CITY OF PORTLAND, MAINE

April 15, 2015

Project Name:	Hotel Redevelopment	Project ID:	2014-220
Address:	1210 Brighton Avenue	CBL:	265 A 1
Applicant:	Portland Hotels, Inc.		
Planner:	Nell Donaldson

Hotel Redevelopment
1210 Brighton Avenue
Level III Site Plan Review
2014-220
Portland Hotels, Inc., Applicant

Drawing file: final final plans_4_1_15 / C2.1 Pavement Marking and Signage Plan.pdf

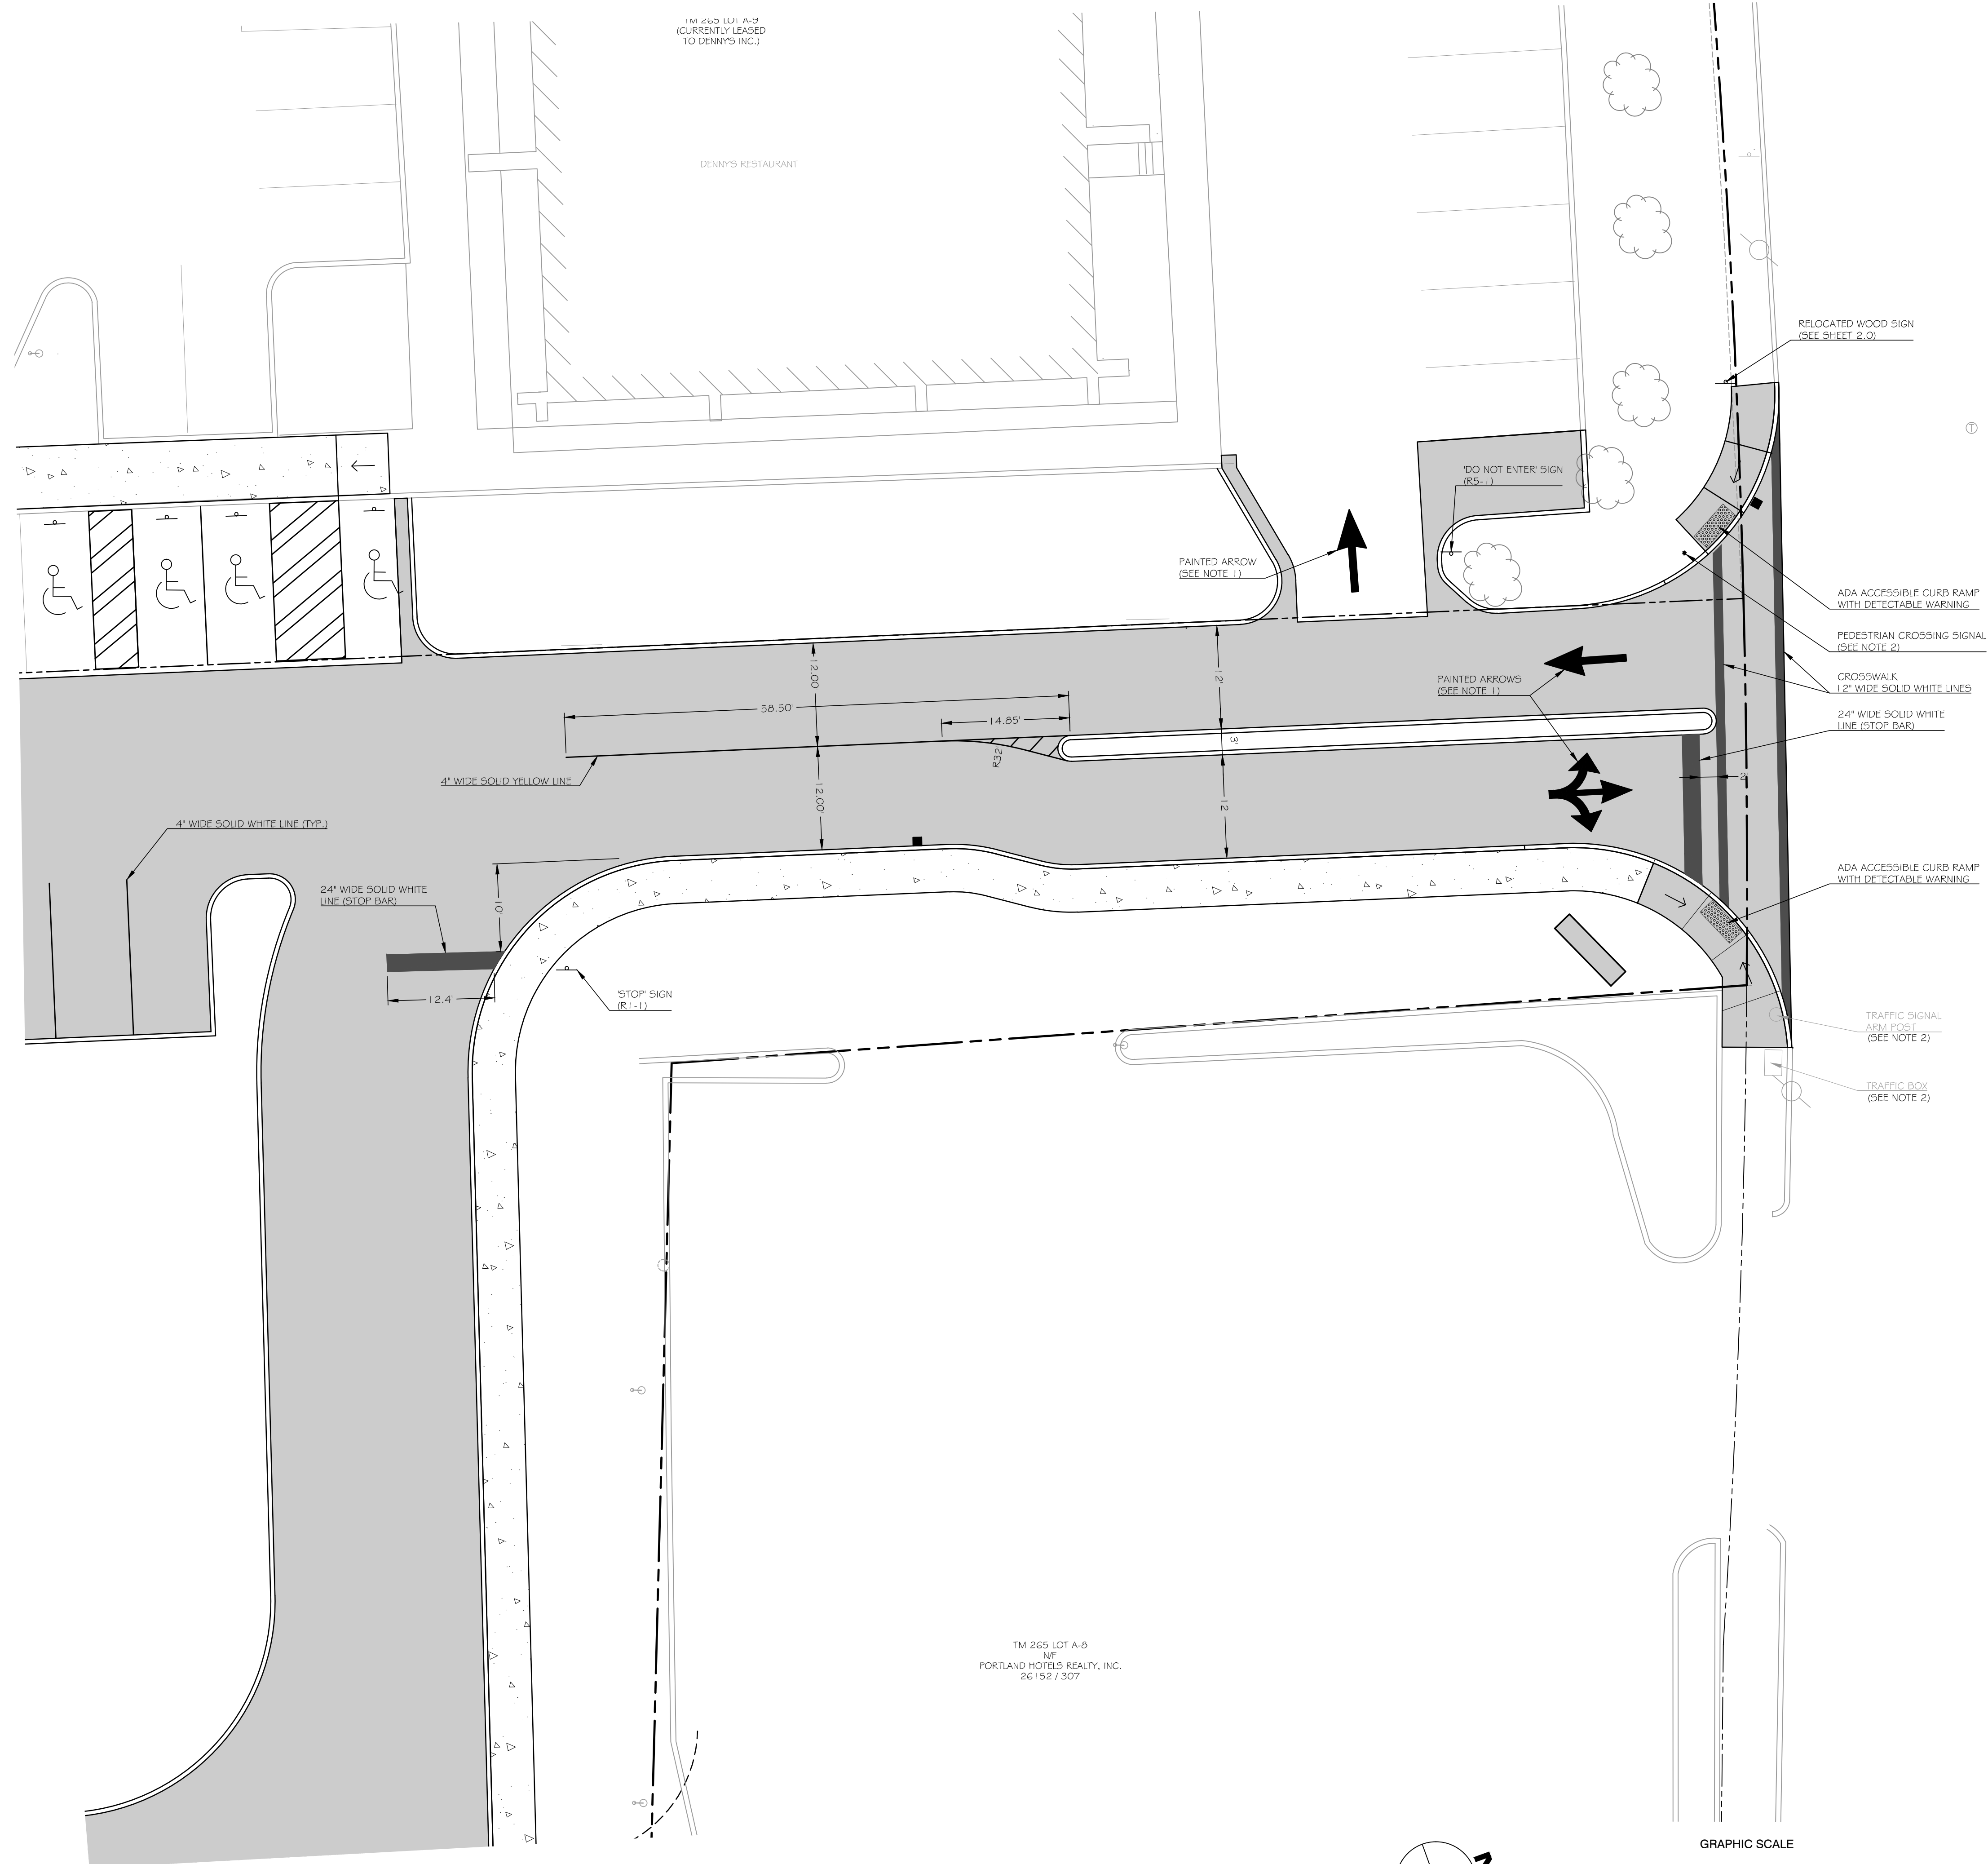
Pedestrian access to and from the site is proposed via a sidewalk, located on the eastern side of the driveway, which connects to all proposed building entrances. This sidewalk would link to both the Brighton Avenue sidewalk system and the Brighton Avenue crosswalk, which traverses the eastern leg of the Brighton Avenue/Riverside Street intersection and from there provides access to nearby food and shopping in Westbrook. Mr. Errico requested that the applicant provide a crosswalk across the site driveway at Brighton Avenue. The applicant shows this crosswalk in their final plans. In his final comments, Mr. Errico notes,

The applicant has provided the requested crosswalk and noted signal modification upgrades. The applicant will be responsible for submitting a traffic signal design plan that details specifications for review and approval by City staff.

2. The applicant shall submit a traffic signal design plan for the Brighton Avenue/Riverside Street intersection for review and approval by the Department of Public Services;

Sheet Title:  
**Post Development  
Drainage Plan**

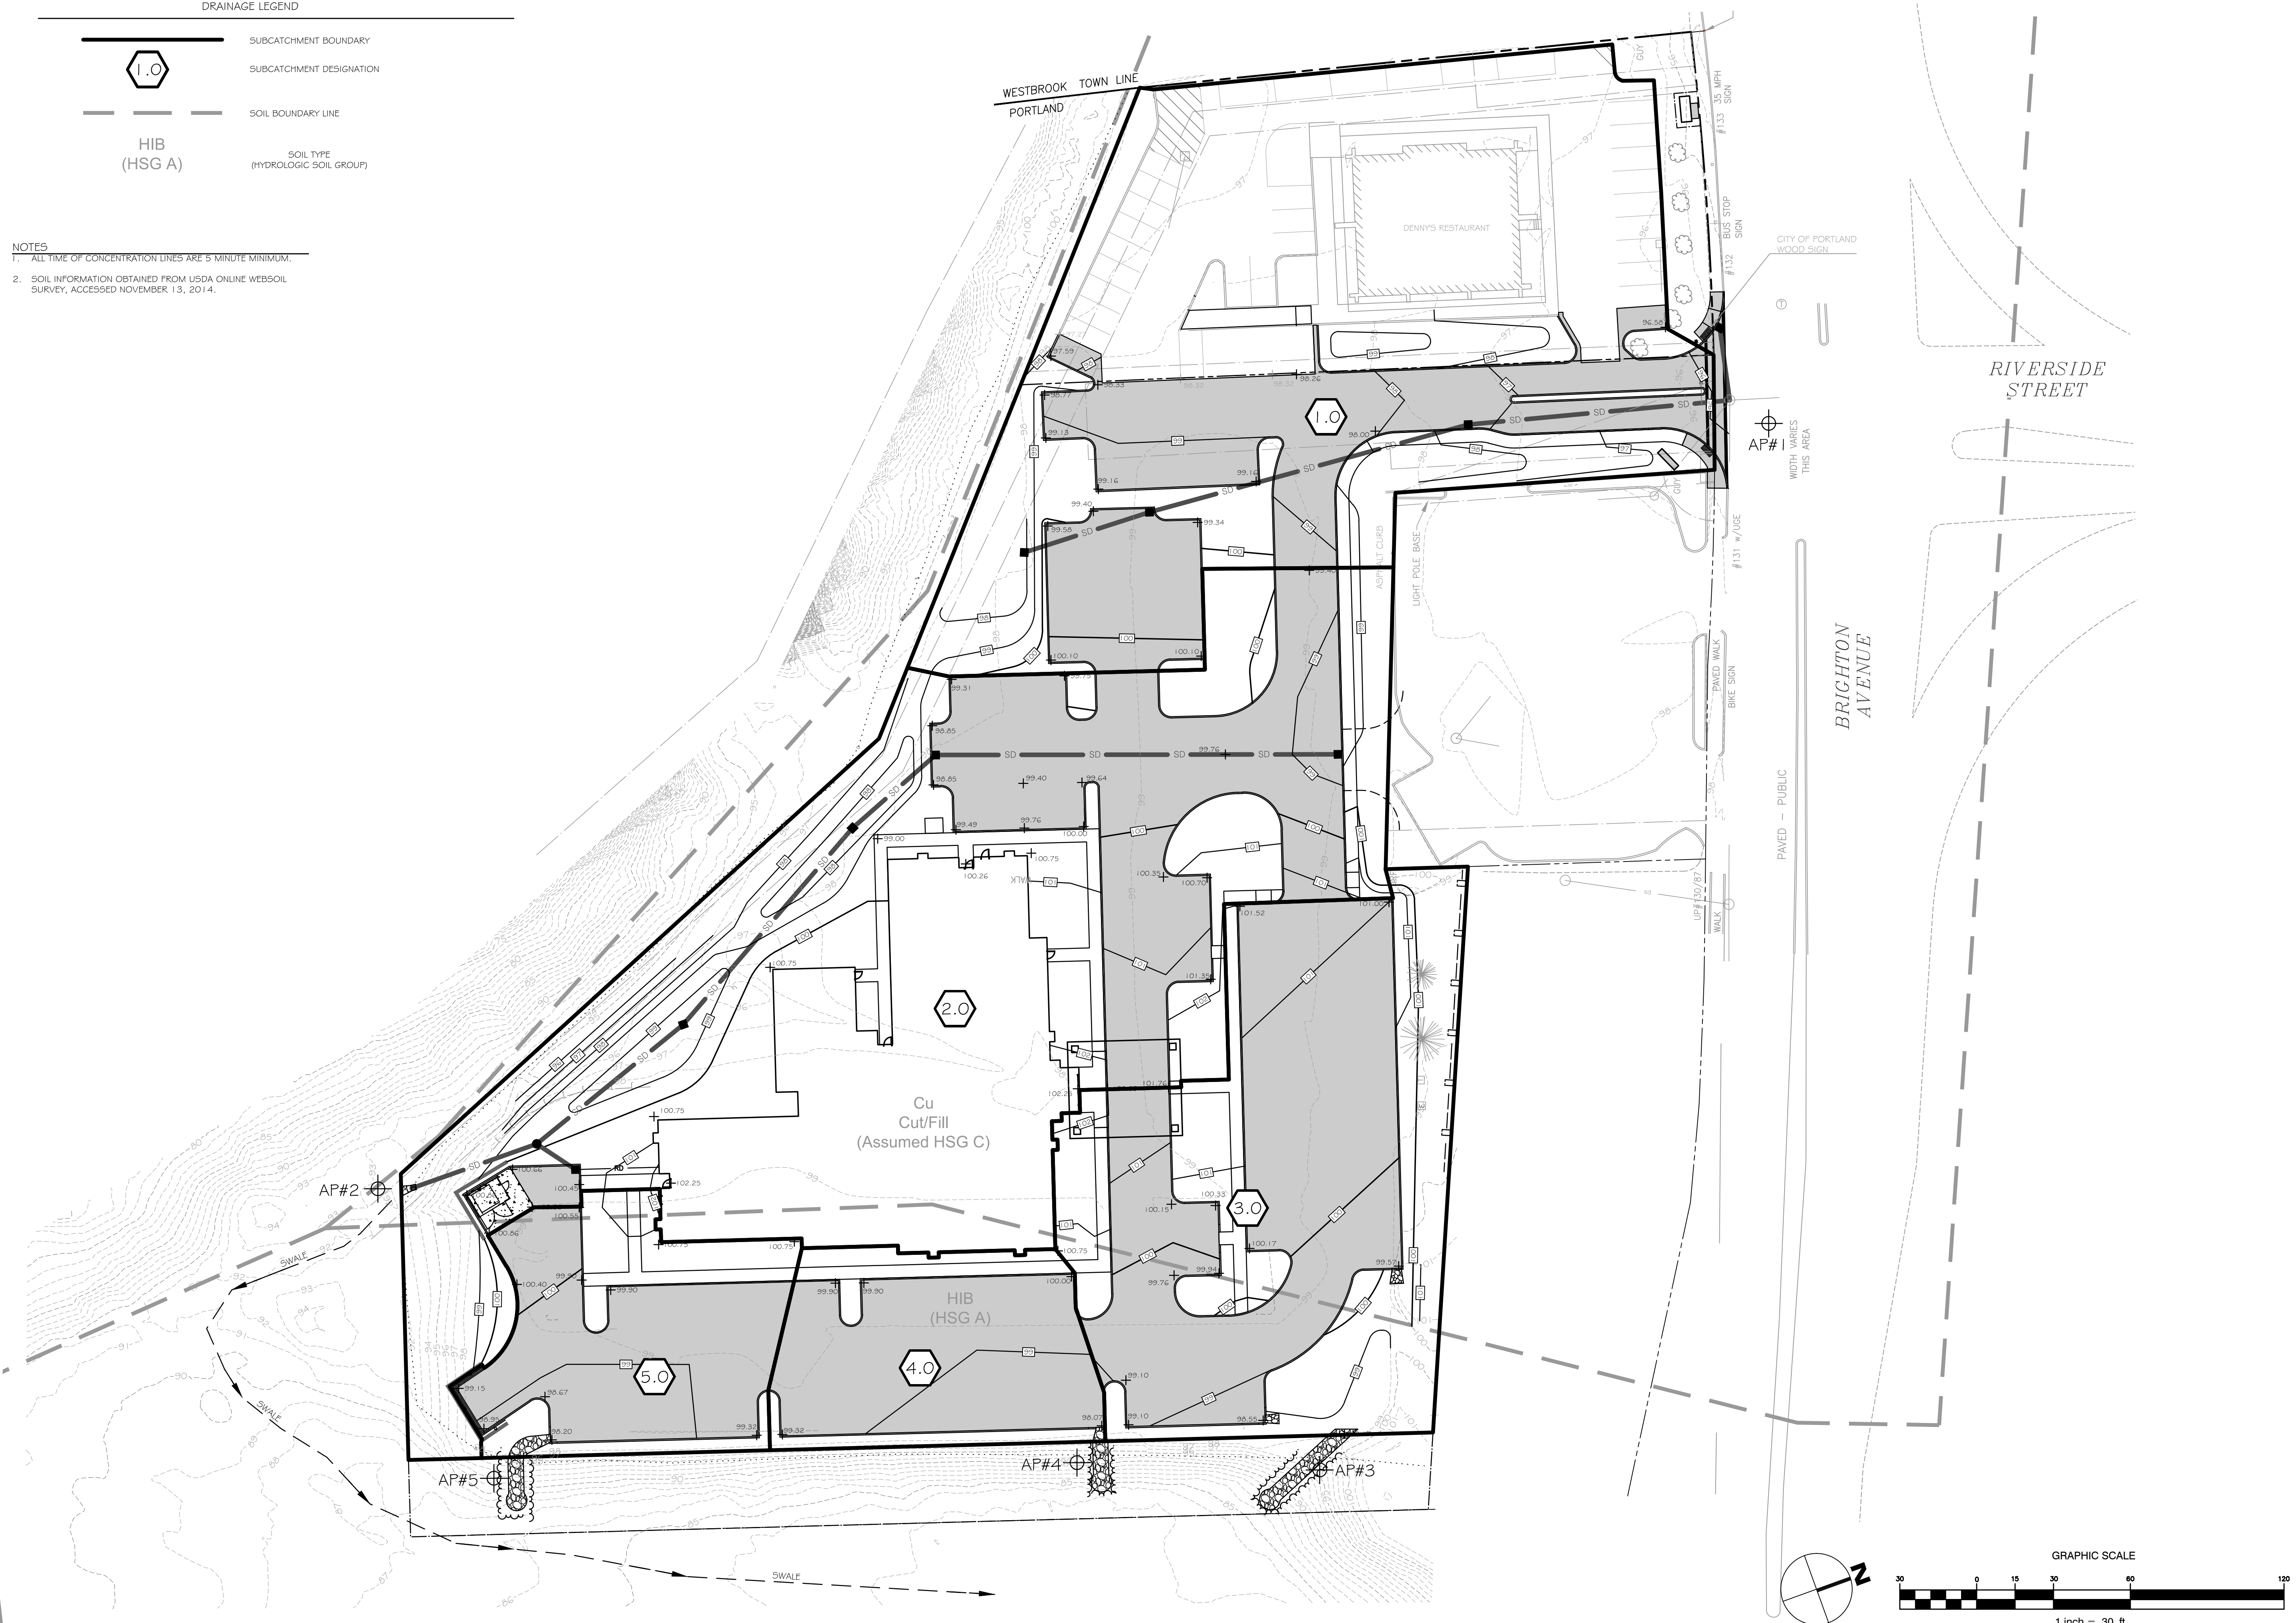
4. The applicant shall provide documentation, in both written and photographic form, of the condition of the stormwater outfall labeled AP#2 on Sheet D2.0 and provide design details for any additional stabilization measures required, to be reviewed and approved by the Department of Public Services;

A stormwater outfall proposed on the southern portion of the site (AP#2 on sheet D2.0) discharges to an existing swale within a CMP easement. The Applicant proposes a riprap apron at the pipe outlet. We recommend that the Site Plan approval include a condition requiring that the Applicant's engineer inspect the stormwater outfall AP#2 on Sheet D2.0 and provide a written description and photographs of this outlet, along with any additional proposed stabilization measures as determined necessary for review and approval by the City. Walsh Engineering Associates has stated that they will assess and document the condition of the outfall location once the snow has melted and will provide design details to the city for any additional required stabilization measures.

4. The applicant shall provide documentation, in both written and photographic form, of the condition of the stormwater outfall labeled AP#2 on Sheet D2.0 and provide design details for any additional stabilization measures required, to be reviewed and approved by the Department of Public Services;
